Tel: 01895 250230
Case Officer: Michael Gavin
Email: MGavin@hillingsdon.gov.uk
Date: 12th July 2021
Our Ref: 40711/PRC/2021/102

RE: Amendment to roof and building levels and reduction in density from 2 x 3 Bedroom and 4 x 2 Bedroom flats as previously approved under 40711/APP/2018/4033 to 4 x 3 Bedroom flats & 1 x 2 Bedroom flats

SITE: 27 Ducks Hill Road Northwood

DRAWING Floor Plans	DATE 10.12.20
CLIENT Bramley Building Services	SCALE 1:50 @ AO
DRAWING NO. 7100/D/02	DRAWN J.P.T.
	REV. J

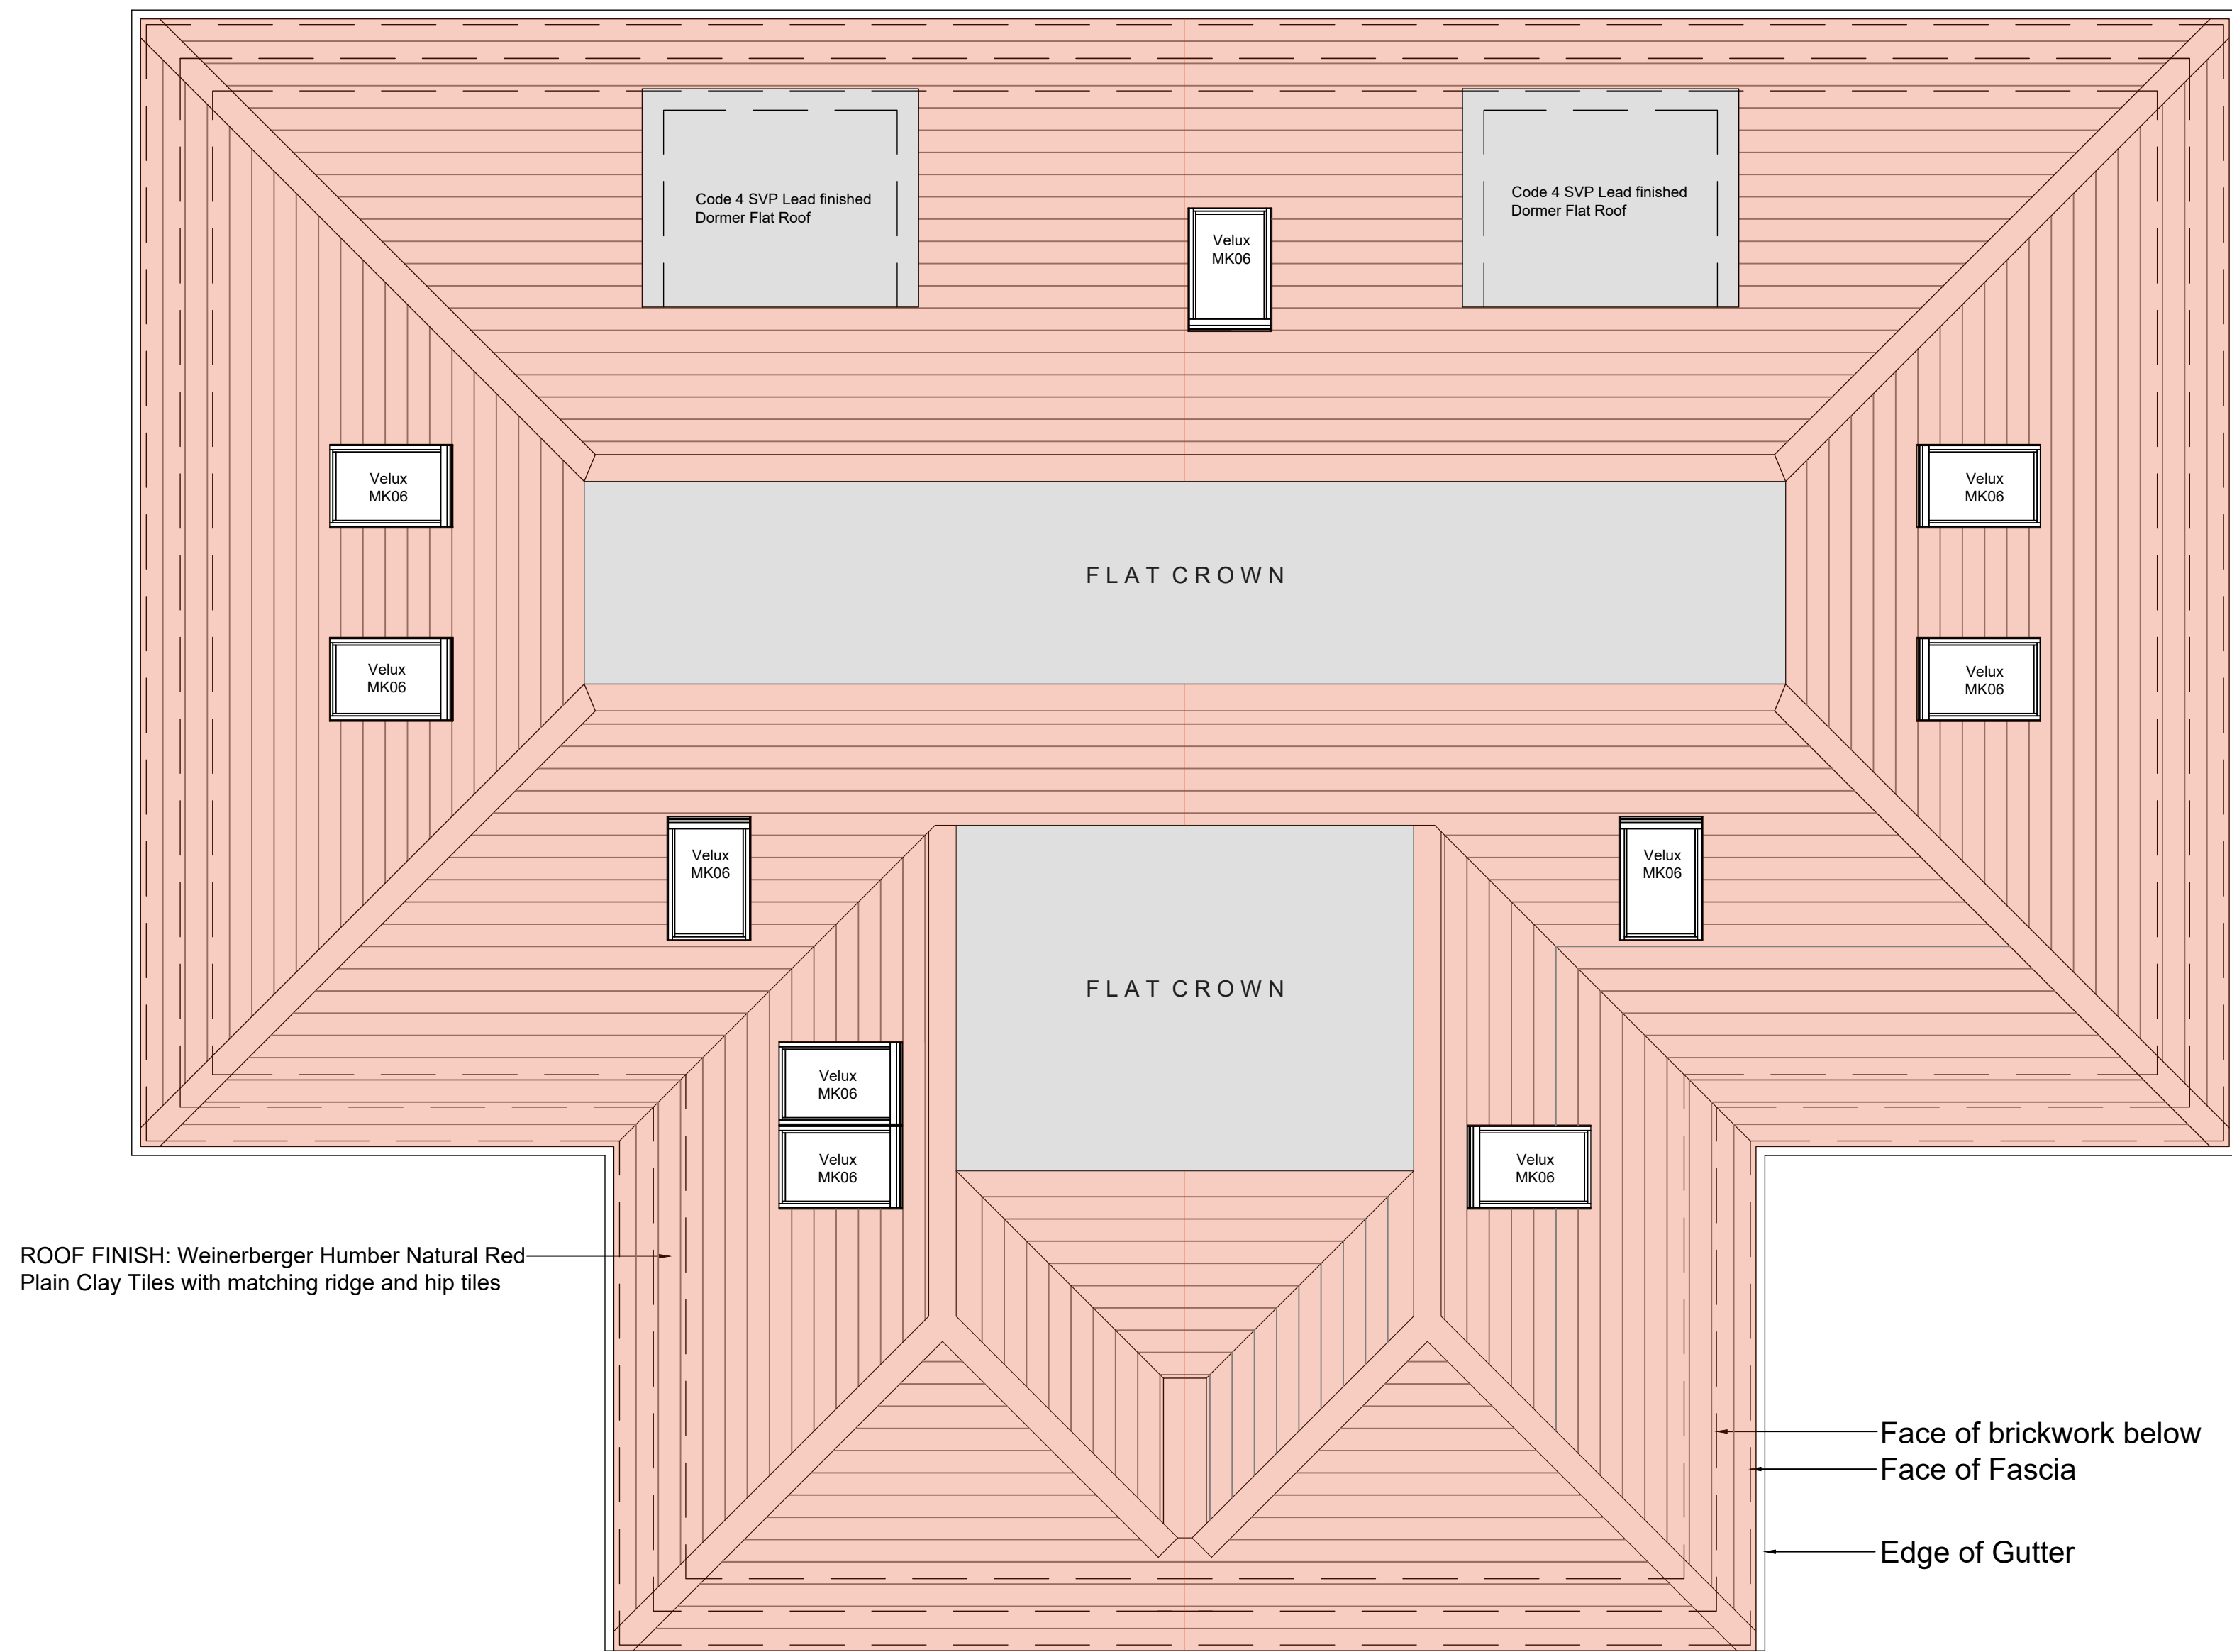
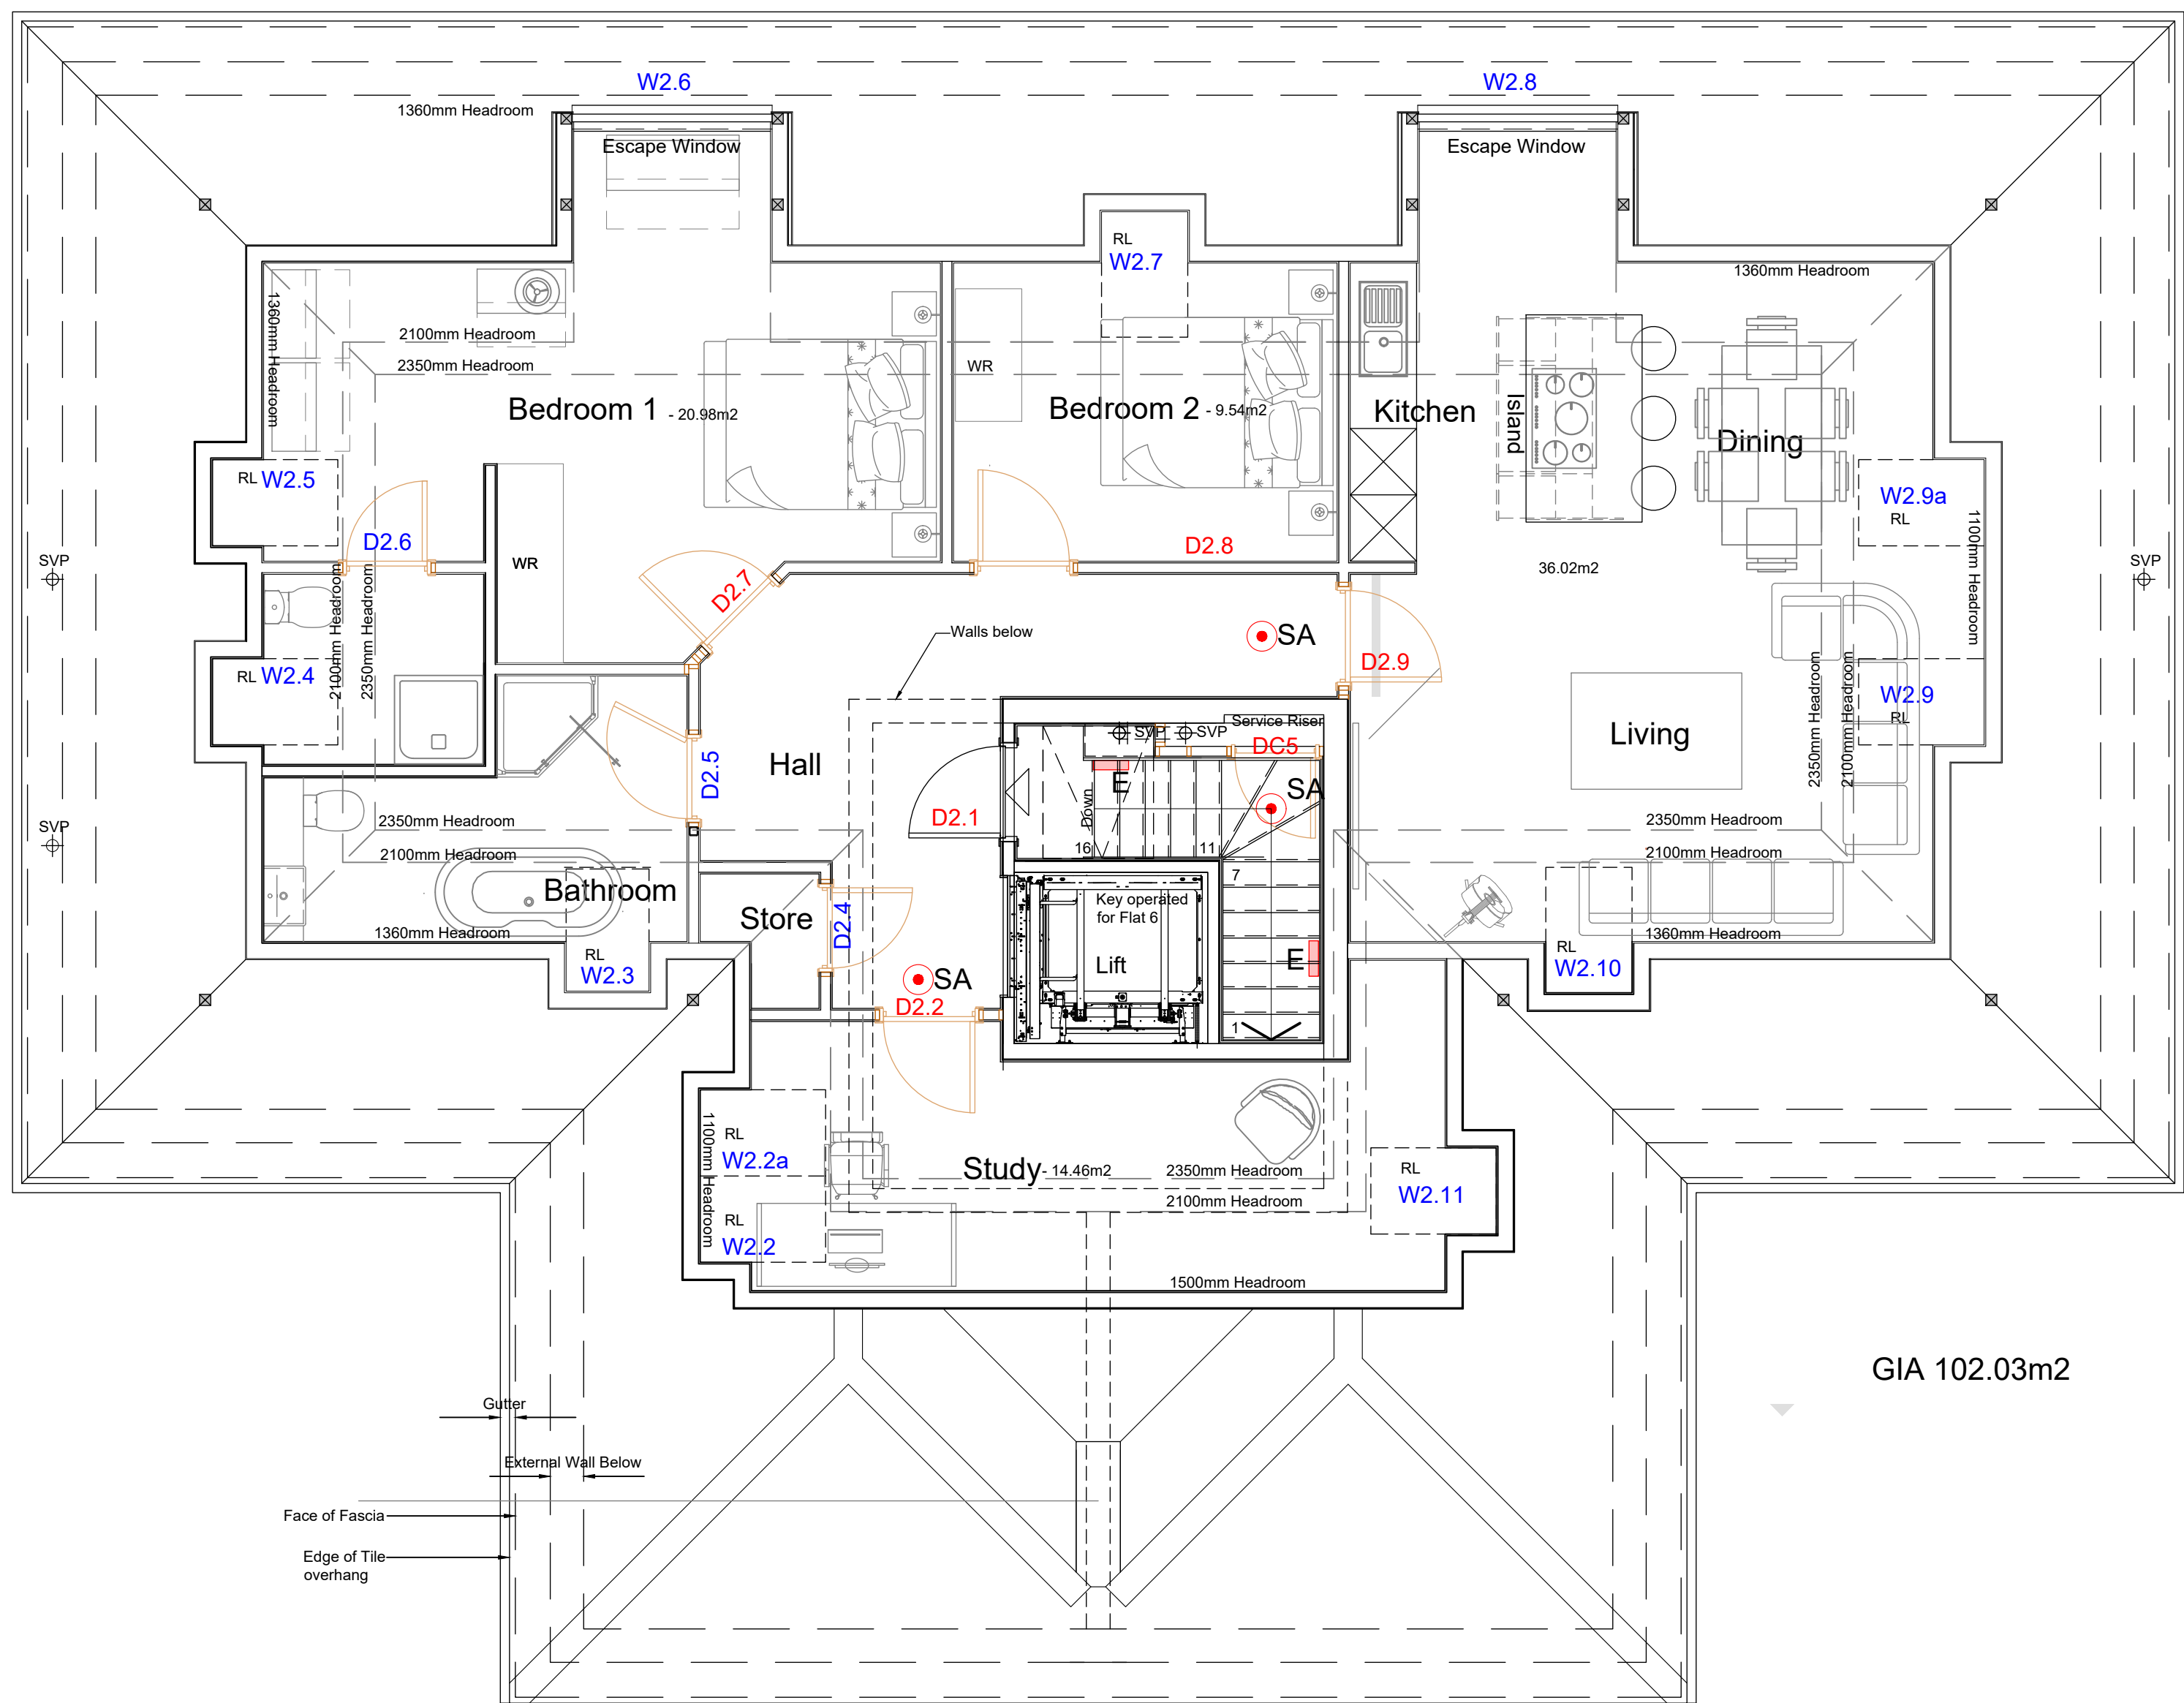
40711/APP/2018/4033 the scheme as amended remains a less attractive building, by virtue of the loss of the overhanging eaves and bulky elevations. As discussed there appears to be scope to reduce the top floor flat in size and still remain in excess of the required GIA for this unit. I appreciate the reasons given in terms of head heights and usability but you may wish to explore further any possibility of further reducing the extent of crown roof over the front projection.

To ensure safe, efficient, and dignified means of escape by people who cannot evacuate by stair, the required passenger lift as shown on plan should be suitable for use during a fire in

Floor plans submitted as part of a planning application should be at a scale of at least 1:100, and should include furnished planned layouts, and clearly demonstrate the access zones and other provisions as set out in Approved Document M to the Building Regulations.
